2280.08-DRAWING REVISION SCHEDULE

PROPOSED SHADOW DIAGRAM - 21 JUNE AT 9AM

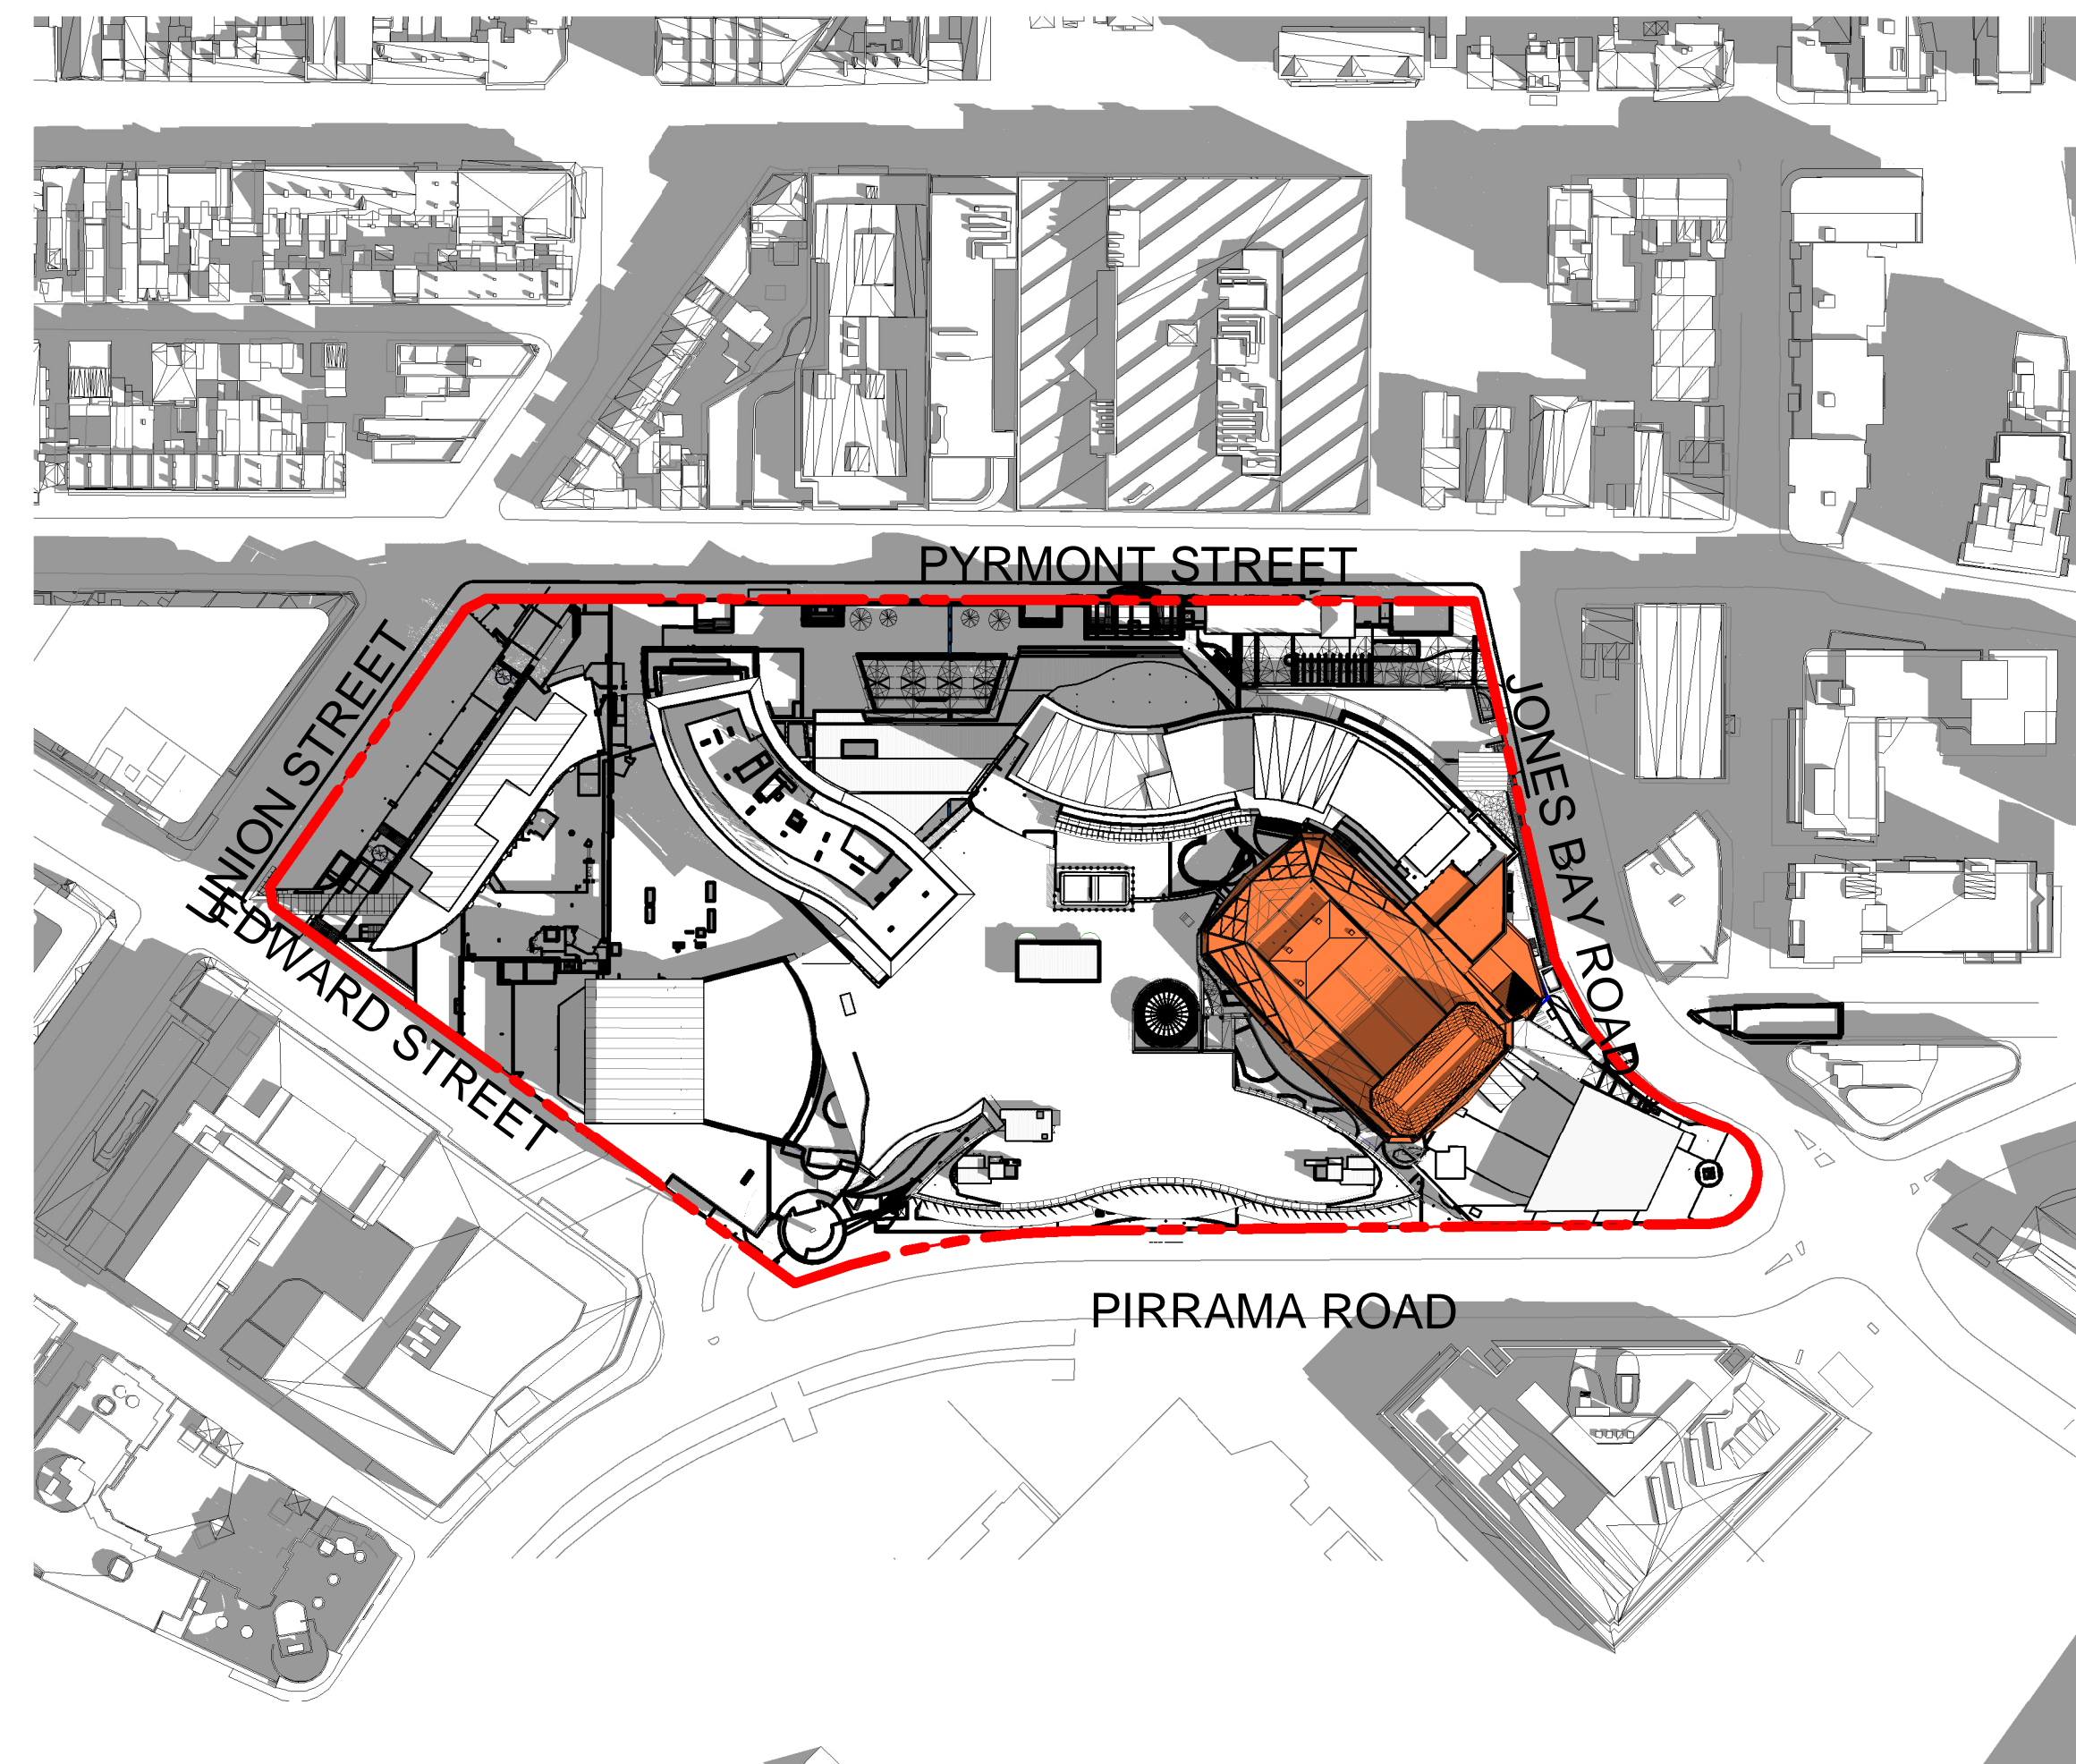
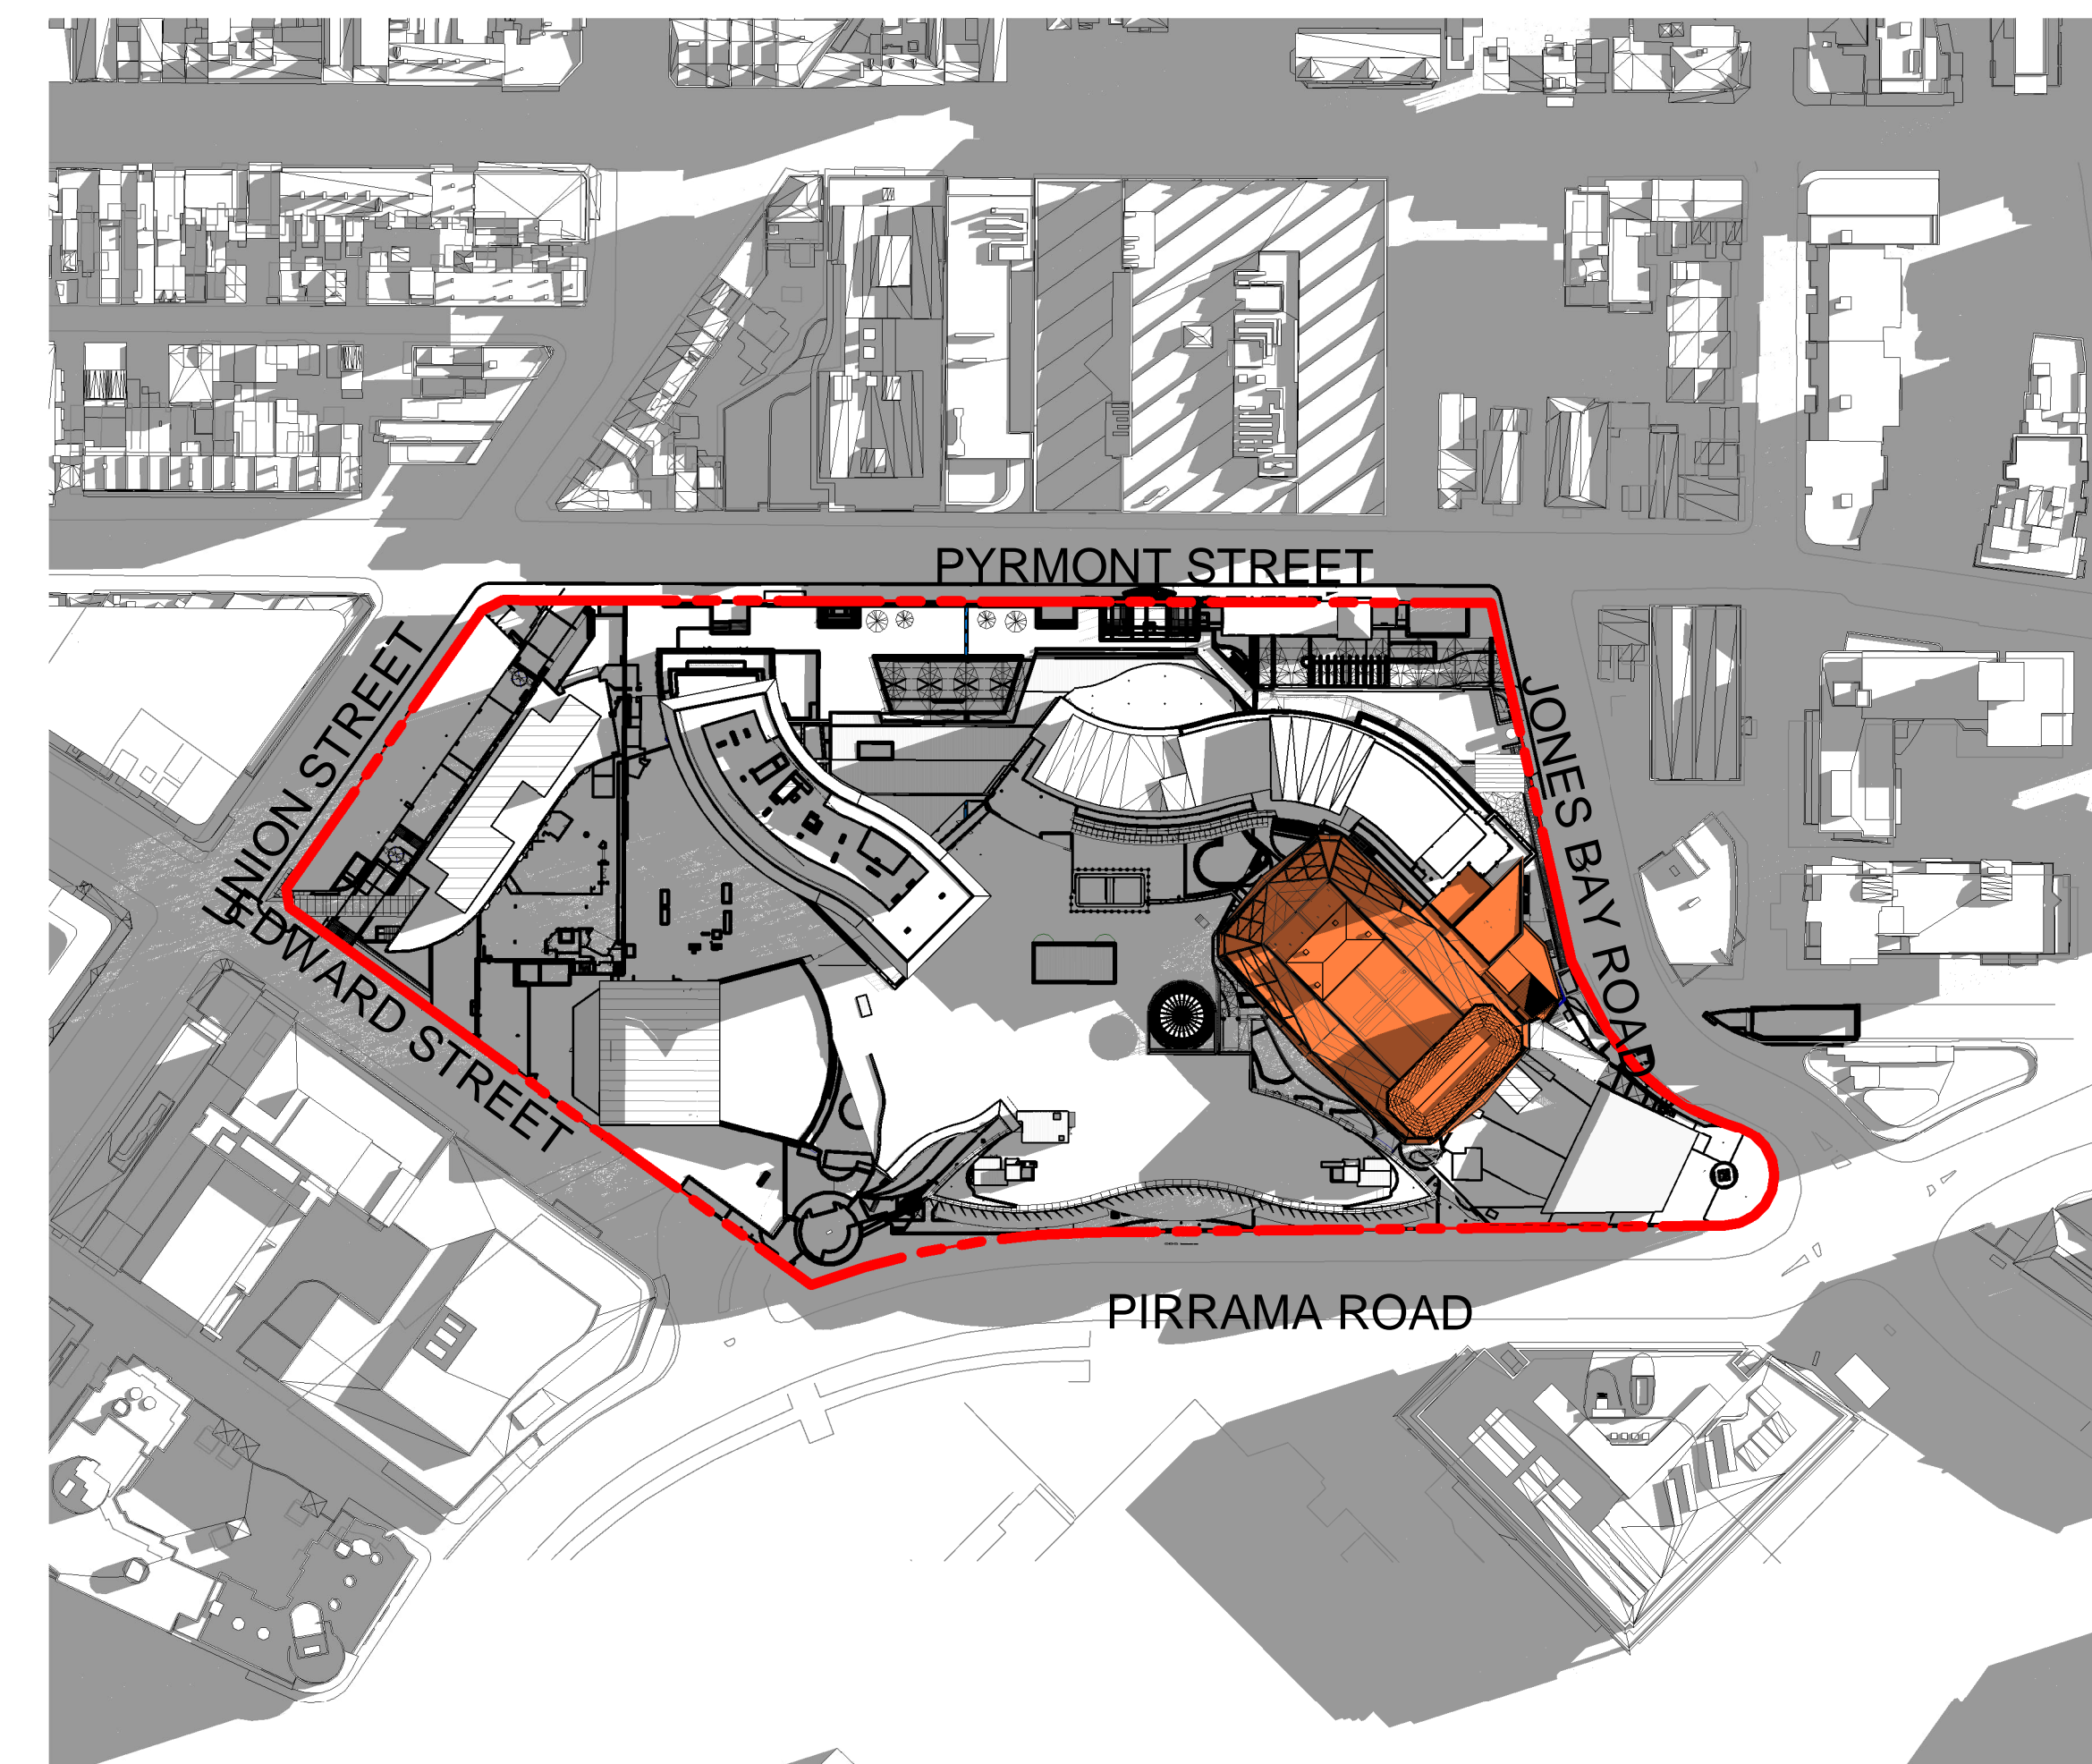
1. Footprint of fly tower reduced to suit comments from DPE and City of Sydney.
2. 4 level extension over existing dressing rooms reduced to 3 levels over existing dressing rooms. Aluminium clad screen extending from 4 level extension and on front of existing plant room omitted.
3. Double height plant room extension omitted from scope.
